PROJECT TITLE Commercial Building  
Don W. Grady, Owner TYPE OF SUBMITTAL \_\_\_\_\_

ZONE ATLAS PAGE NO. J-20-D/S CITY ADDRESS 1405 Eubank Blvd NE

RE: 1405 Eubank Blvd. N.E.

**GRADING/DRAINAGE for**  
**1405 Eubank Blvd. N.E.**

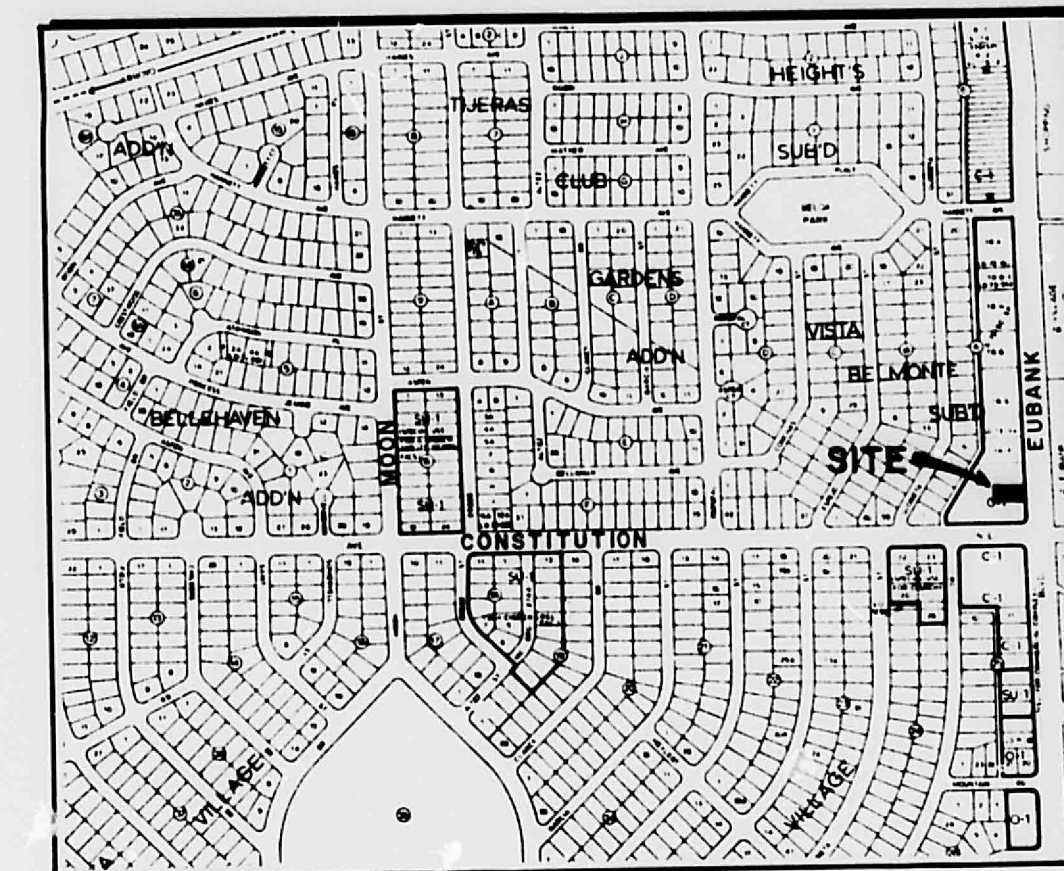
Craig Andrews, architect for the above referenced site, came in today and explained the discrepancy to me between the approved drainage plan and what was actually constructed. The basis of this discrepancy is that the approved Drainage and Grading Plan shows the roof drain emptying into the landscaped area along the parking area, which in turn drains onto the parking area for discharge, across the drivepad. In actuality, the roof drain was piped all the way out into the street for discharge, rather than outfalling into the landscaped area. According to Craig, all other surface drainage patterns have been followed.

In summary, there are insignificant variations in regard to the peak times for the channelized roof flows vs flow thru the landscaped area, but this variation from the approved plan does not ultimately affect the overall sites discharge into Eubank Blvd.
